Town & Country Planning Act 1990 (as amended)

Remove existing single storey garage and replace with 2-storey extension.

5 Denham Close Bognor Regis

DRAWING TITLE:  
**PLANNING**  
Location & Block Plan: proposed Floor  
Plans: Proposed Elevations.

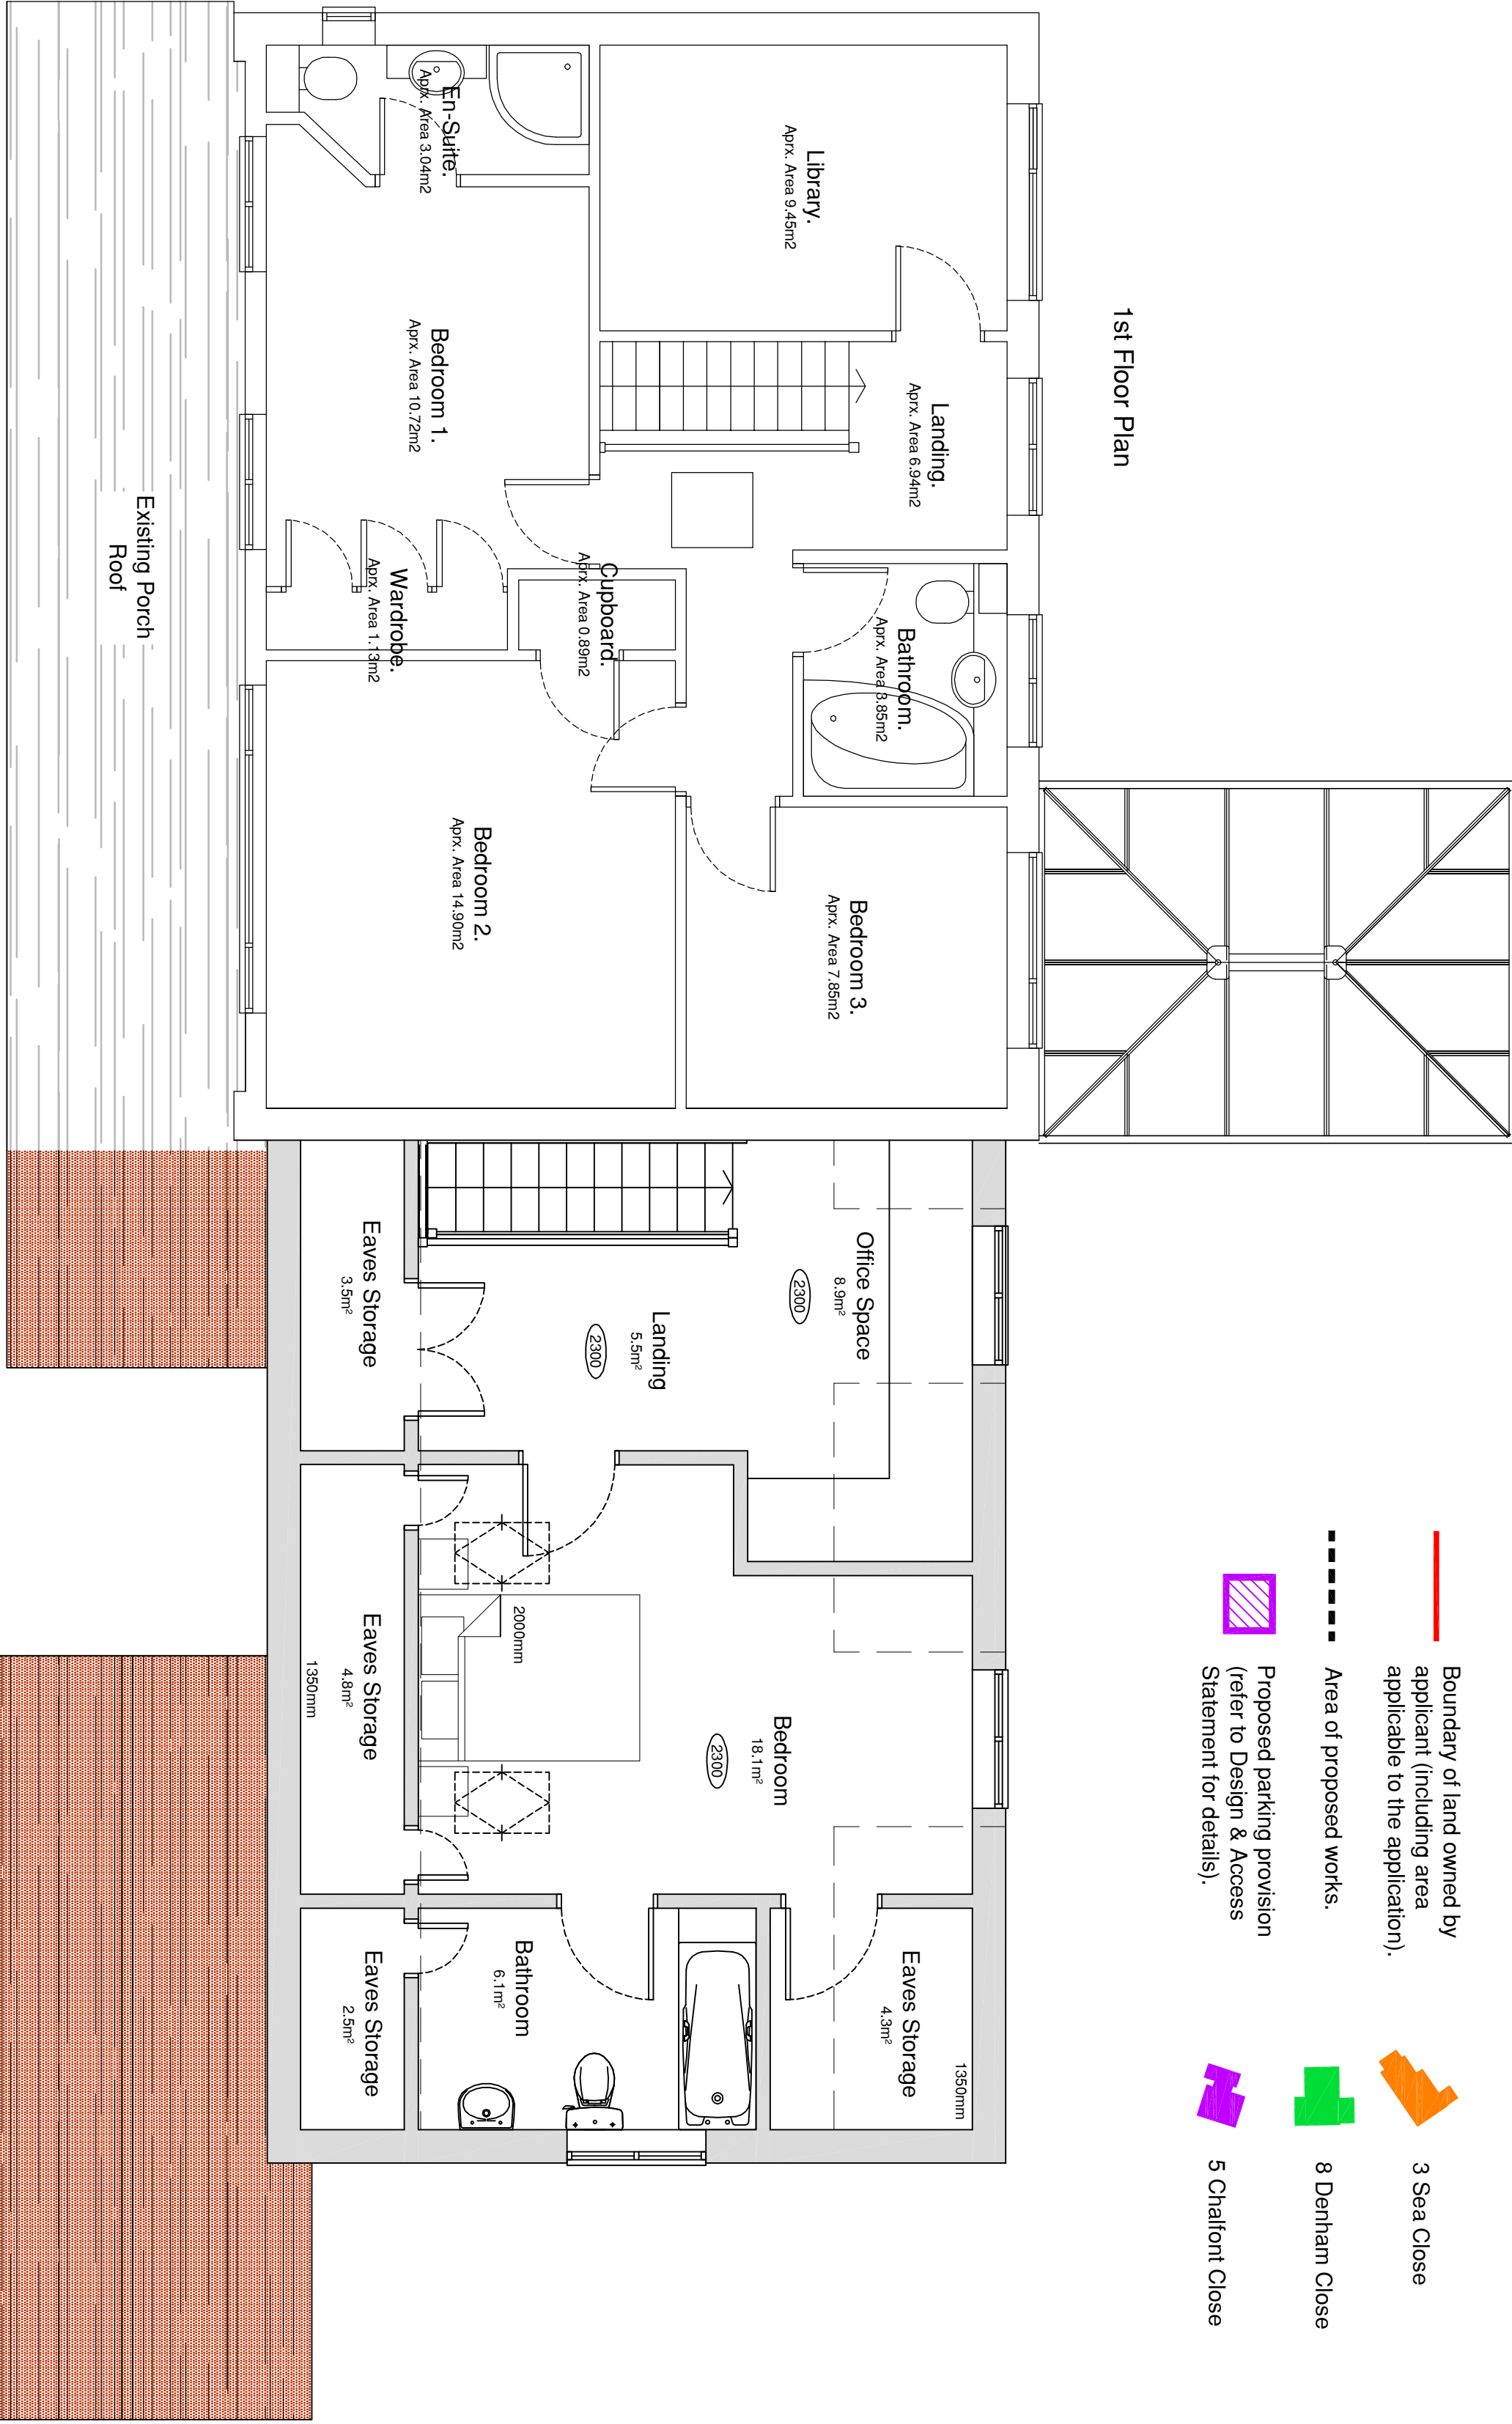
We have no objections to the building as such. However we are a little concerned about parking of cars. A new home in the quiet cul de sac will mean increased cars visiting the new residents as well as existing residents Mr and Mrs Hudson. The plans show parking spaces at the front of each property however in sighting these spaces it seems a little on the tight side to place cars there, which would mean that the road and cul de sac will be used as a constant parking solution. As a temporary solution parking in the road is fine. On the other hand Mr and Mrs Hudson and planners may have already "tested" their front garden to see if it would house all of the vehicles.
